A57 Link Roads Scheme DCO Application

**Representation and response on behalf
of the Peak District National Park
Authority to the Examining Authority's
questions within the Report on the
Implication for European Sites FINAL
requested for Deadline 9**

**Produced by the Peak District National Park
Authority (April 2022)**

Application by Highways England for an Order Granting Development Consent for A57 Link Roads

Insert 1 Scheme overview AADT Flow 2025

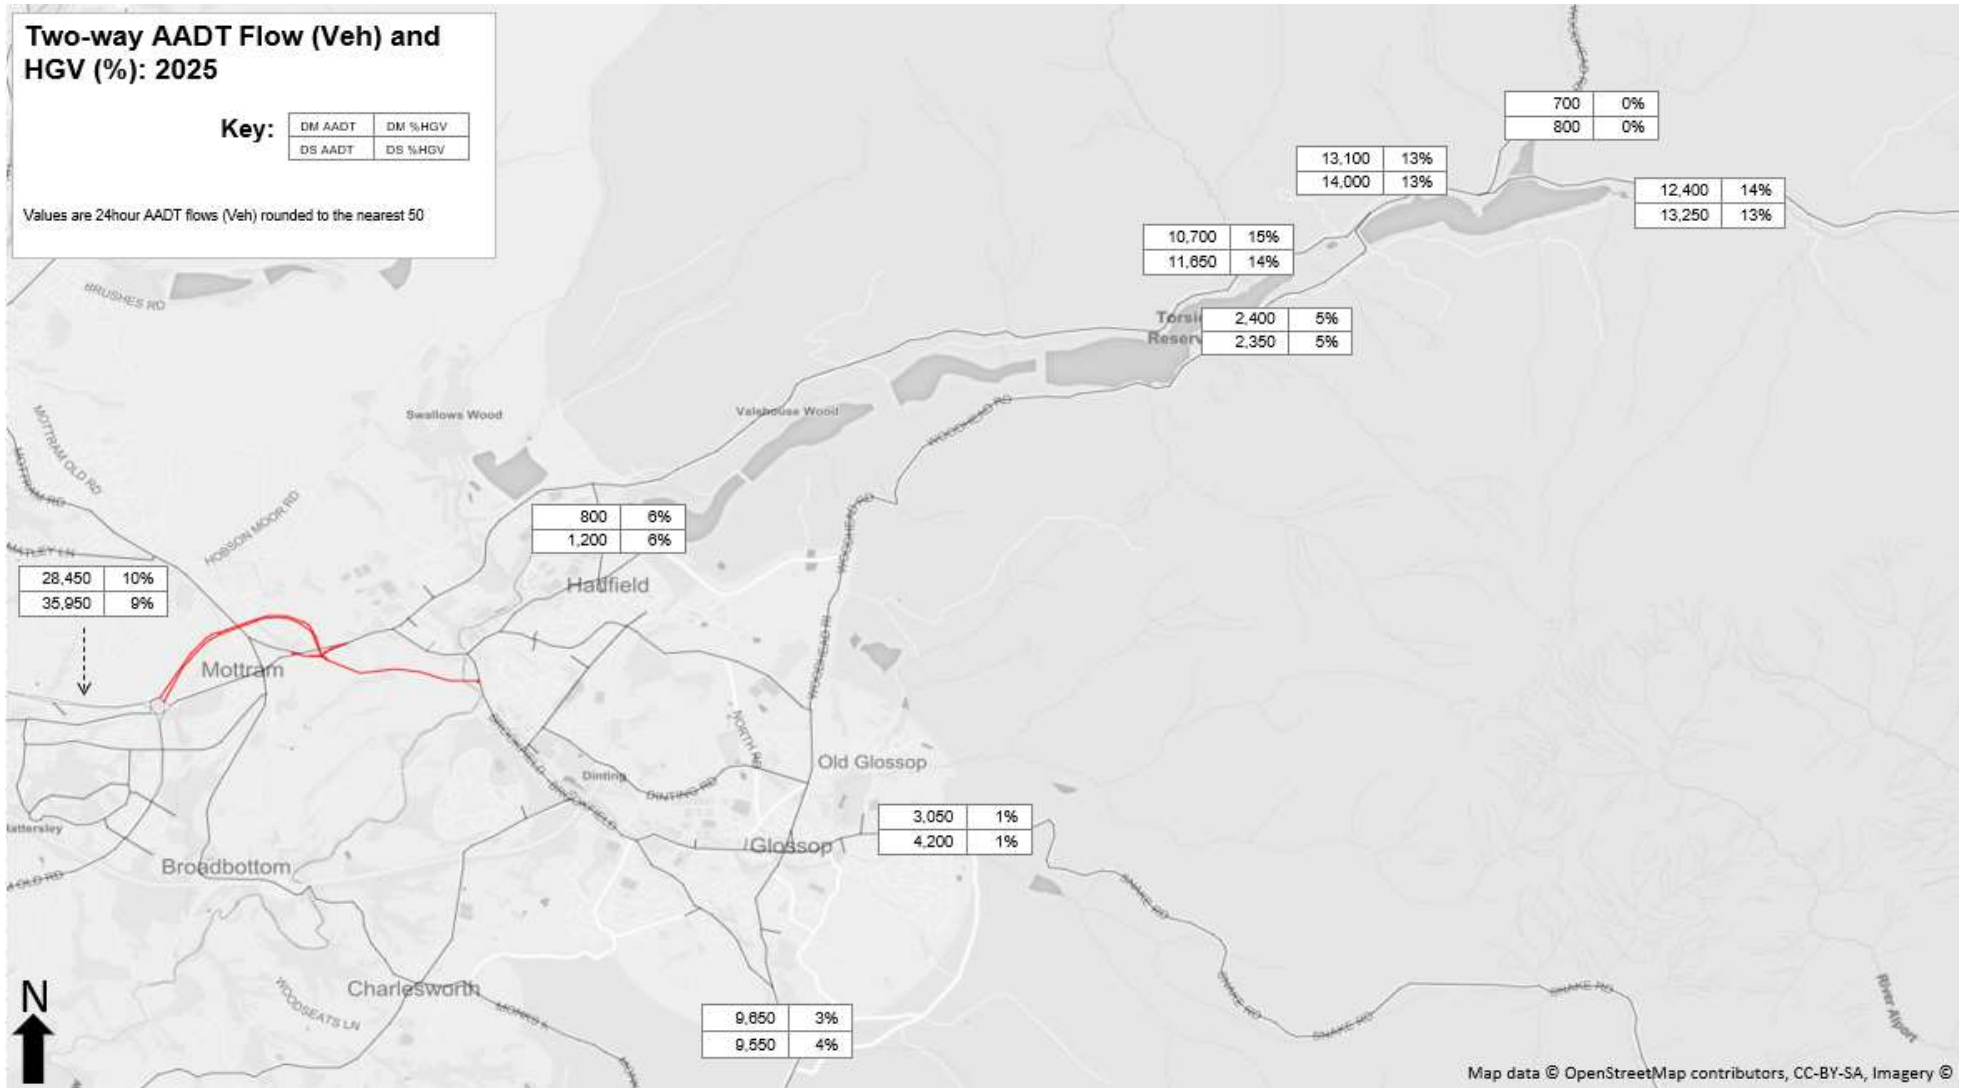
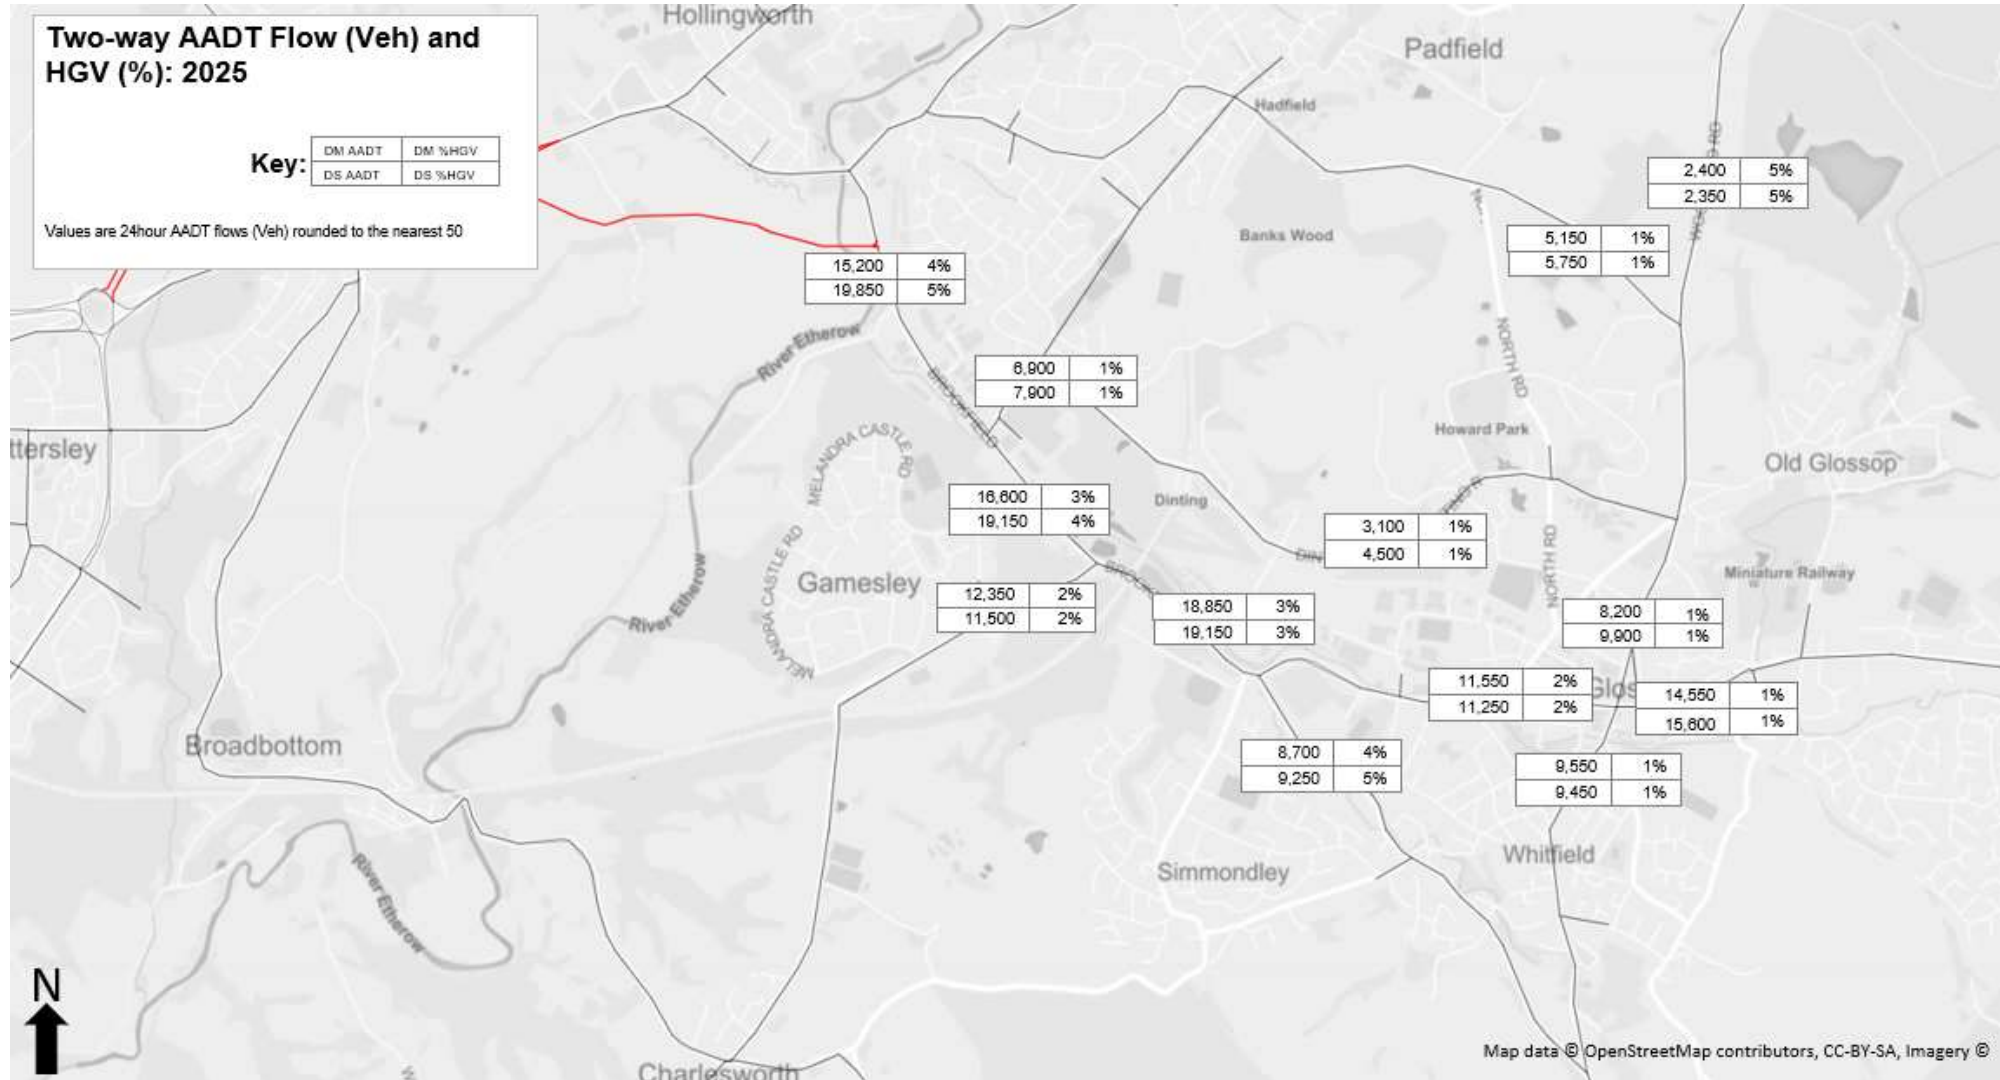
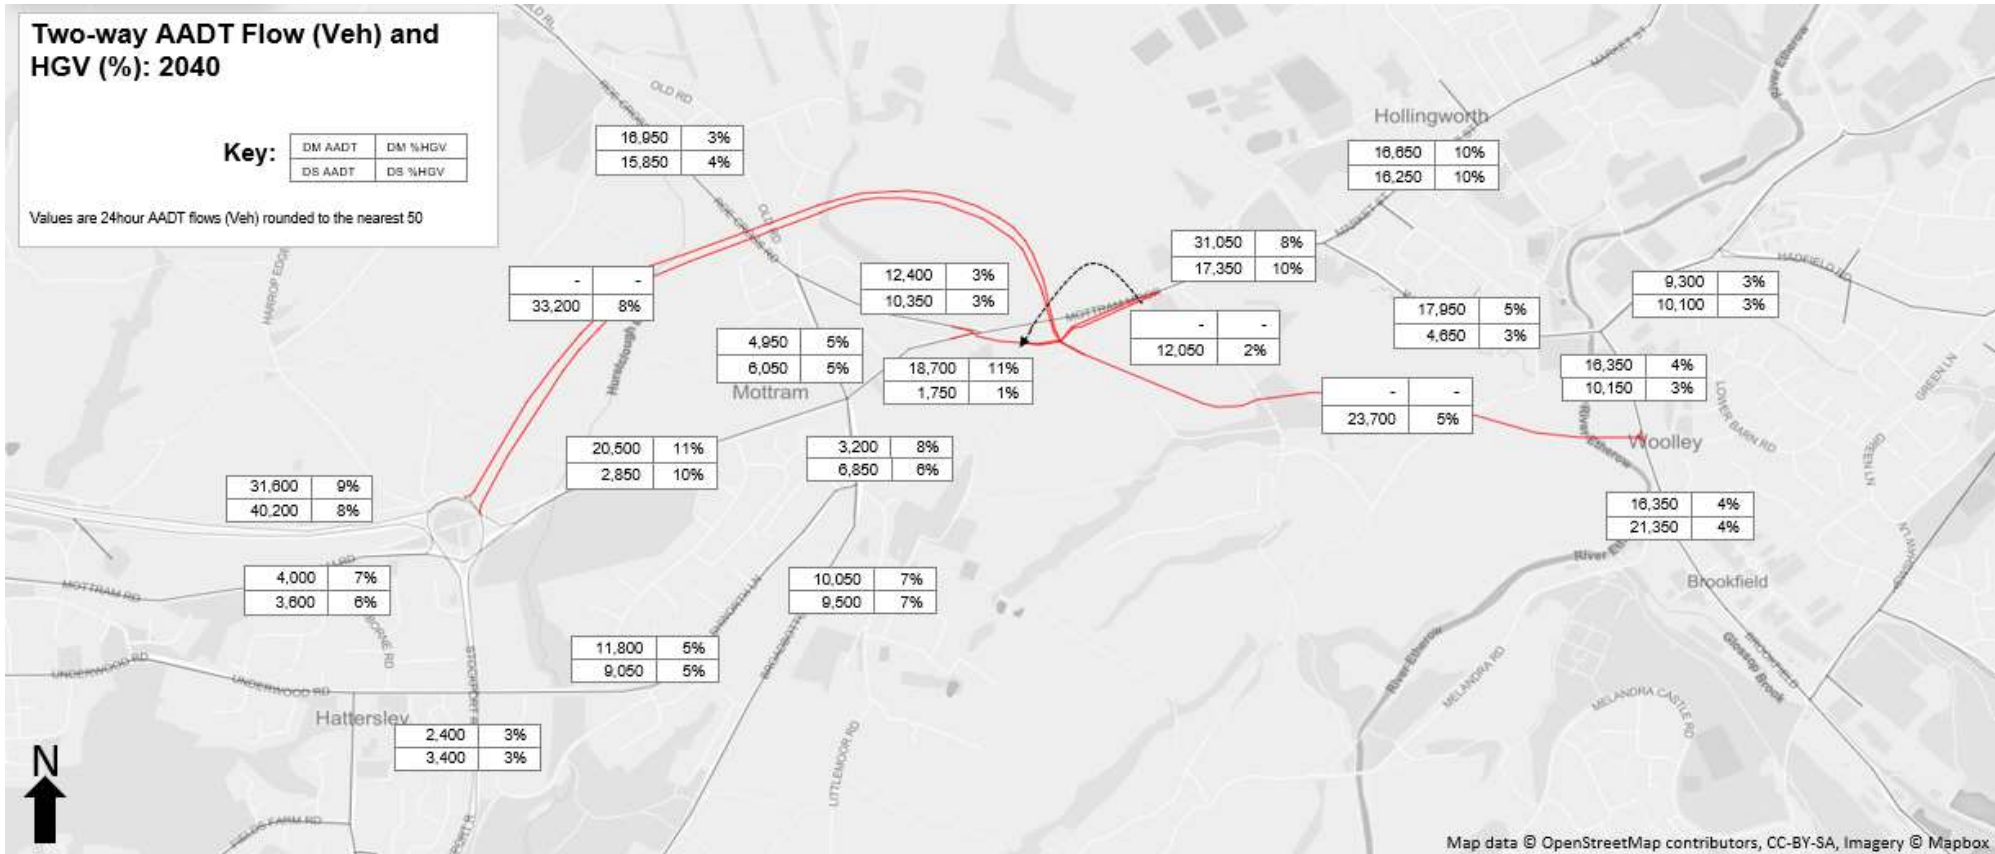
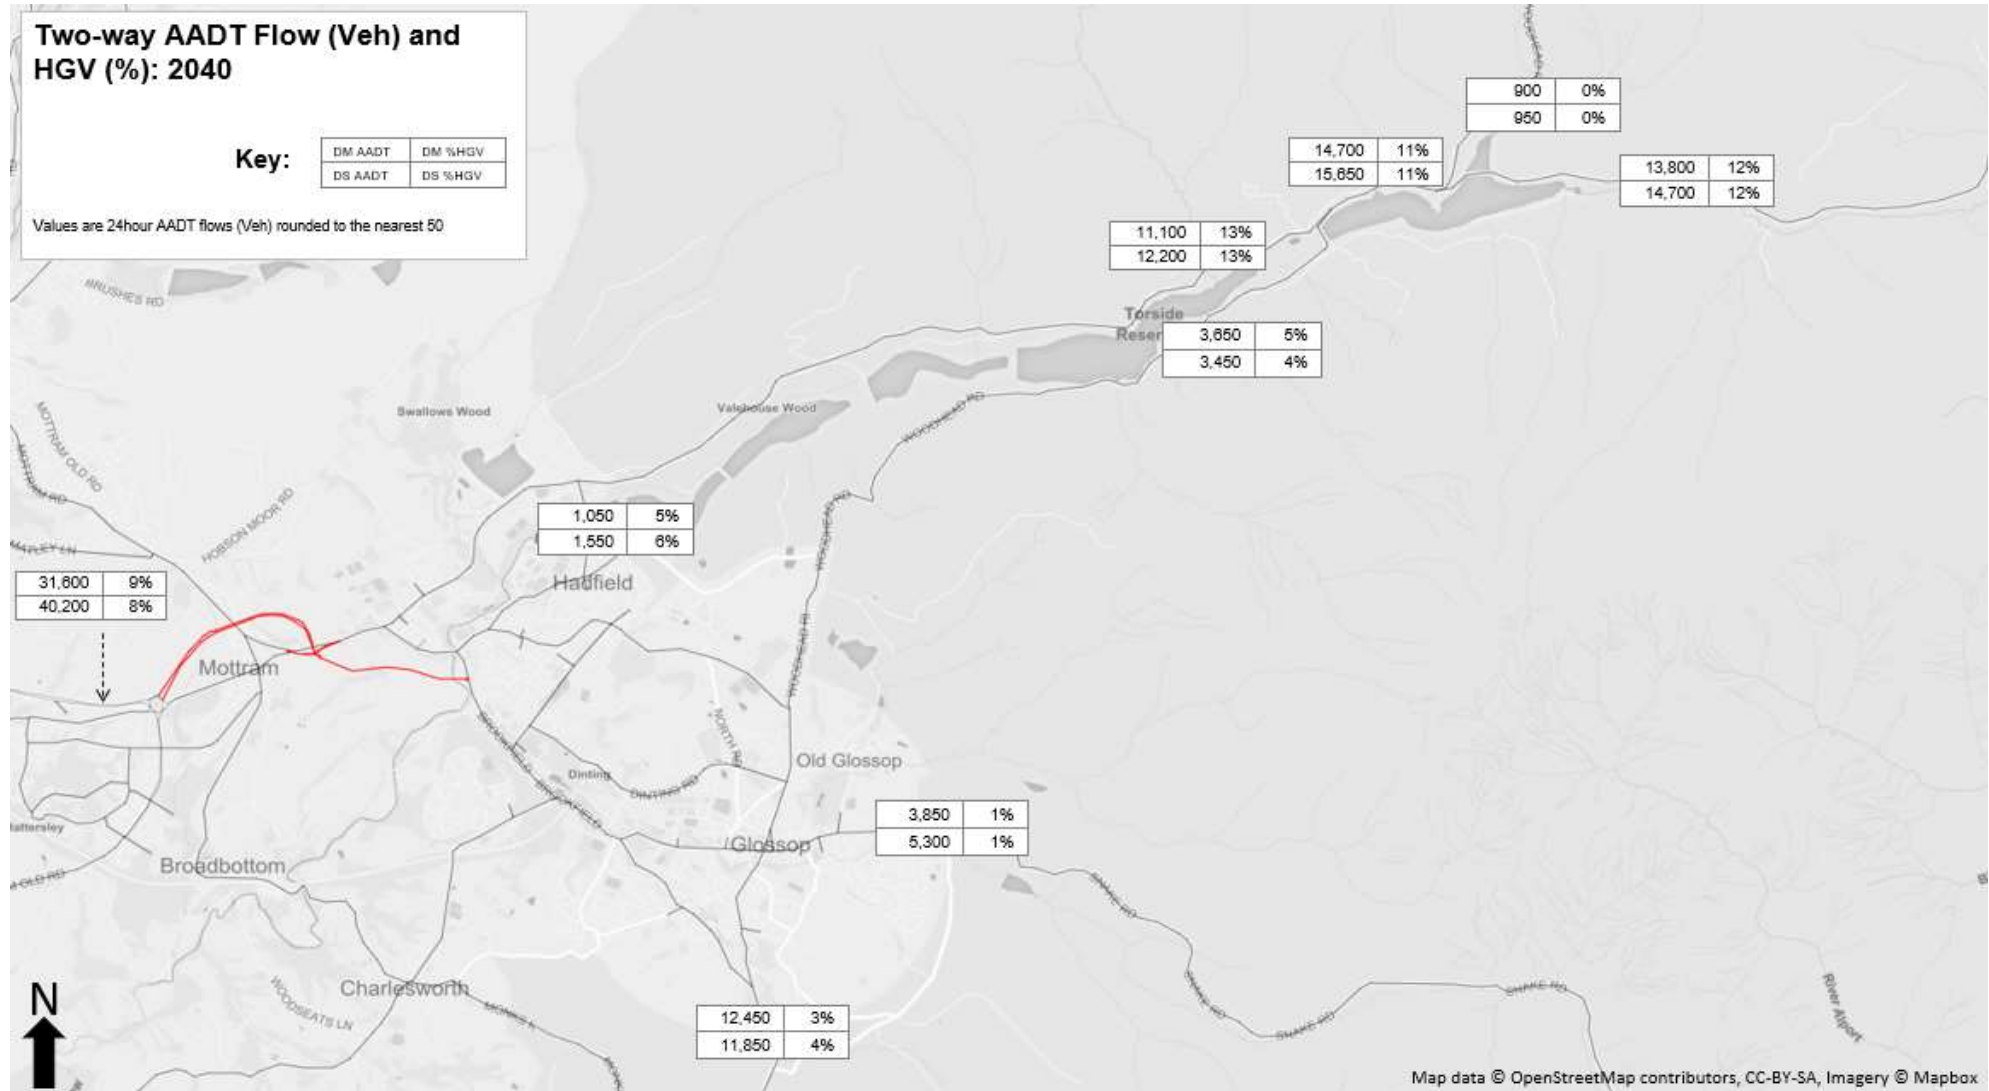
We re-iterate our concern that no statistical confidence levels for the predicted traffic flows appear to have been submitted, and it is therefore entirely possible that the predicted increases in traffic levels could exceed the AADT thresholds set out in the DMRB, and therefore require further assessment.
Peak District Moors (South Pennine Moors Phase 1) SPA	Issue- Habitat changes affecting availability of prey species	<p>ExA request- No specific request, but assumption that lack of comment from PDNPA means we do not consider there to be a likely significant effect from this pathway.</p> <p>PDNPA Response</p> <p>We confirm we do not consider a significant impact likely from this pathway.</p>
